Application No: R/90/22/HH
Site Address: Kingfishers 10 Fosters Close Rustington BN16 2TL
Description of works: Single storey side garage extension, front porch extension, hip to gable loft conversion including the installation of front dormers and rooflights and alterations to fenestration/openings.

Thank you for your internet representation made on 16th May 2022 which has been recorded as an objection with the comments as follows:

PROPOSED EAST ELEVATION 1:100

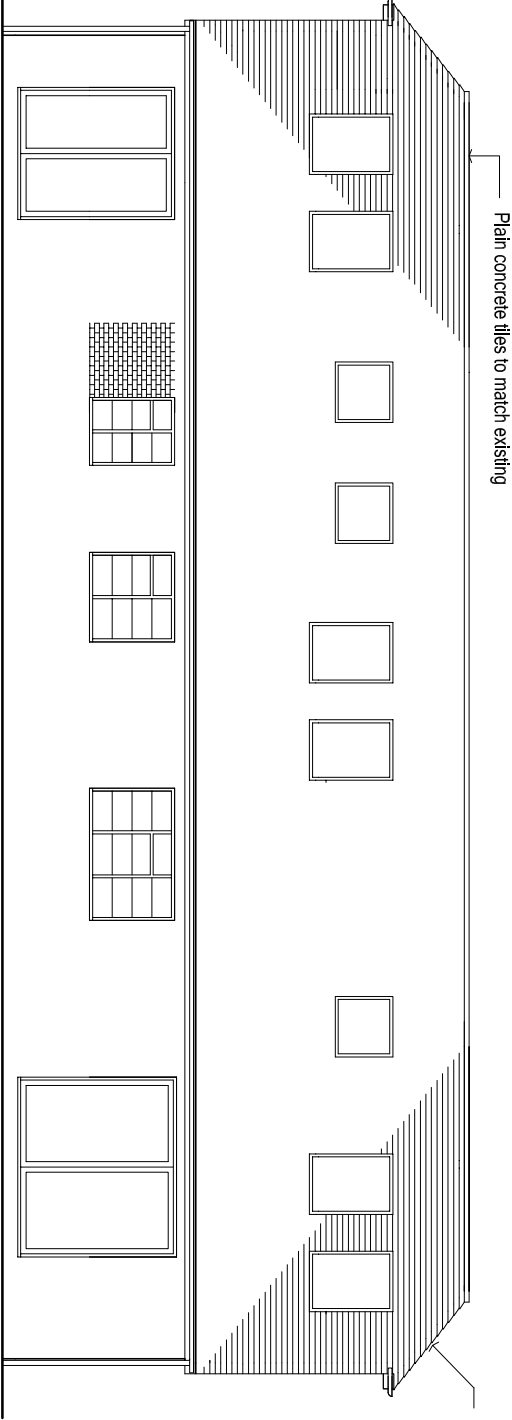
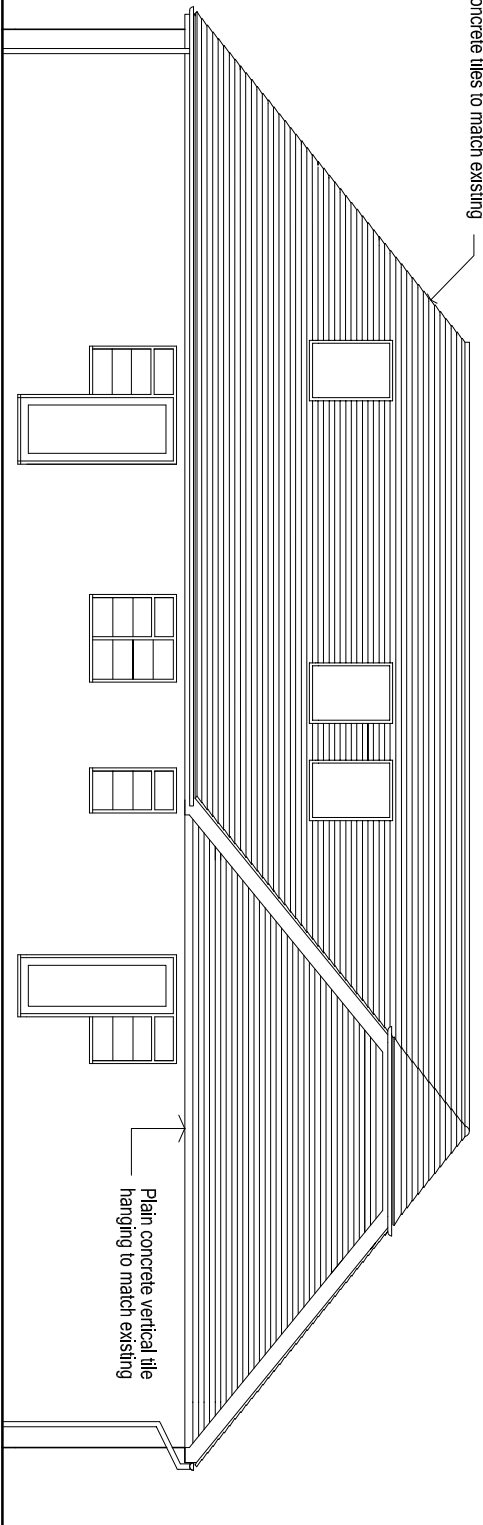
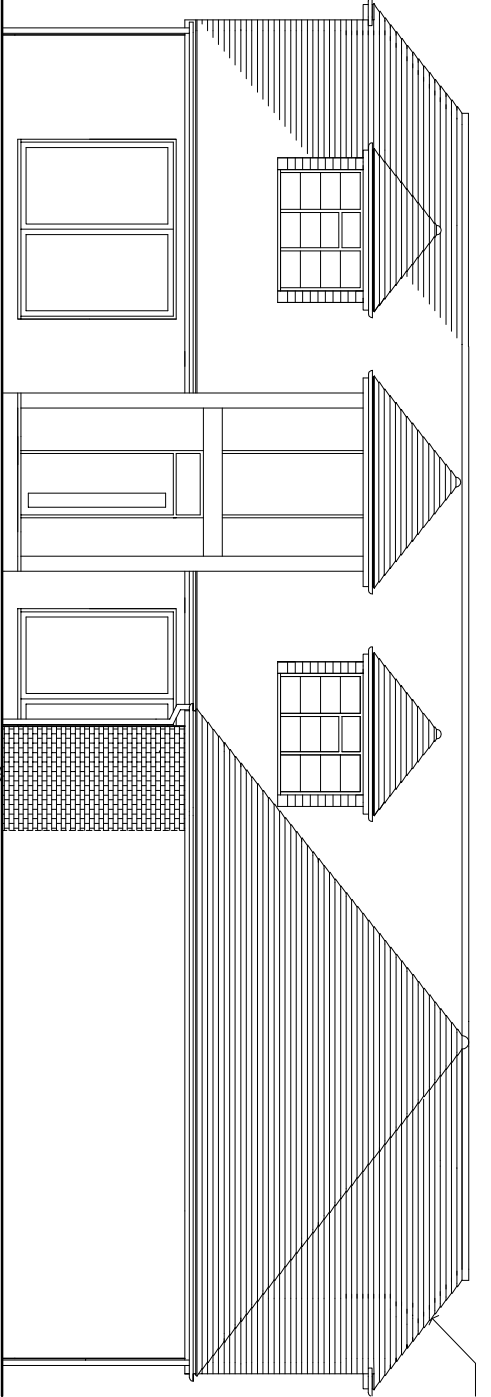
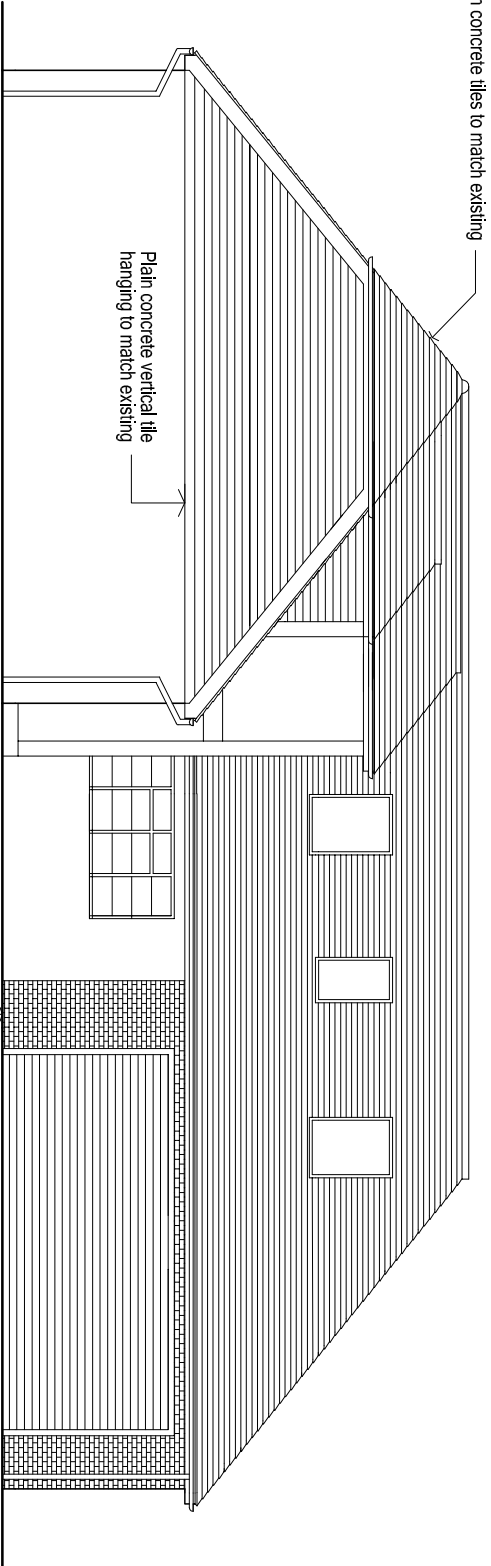
We strongly oppose the Planning Application regarding the proposed development of 10, Fosters Close. Our rear garden is adjacent to the rear of 10, Fosters Close where the original building of the said property is already very close to the fence boundary and therefore the proposed Velux windows on the East elevation would be overlooking our property including the Main house family bedrooms. We consider the proposed Application a profound loss of privacy and also an overdevelopment which is not in keeping with the surrounding area.
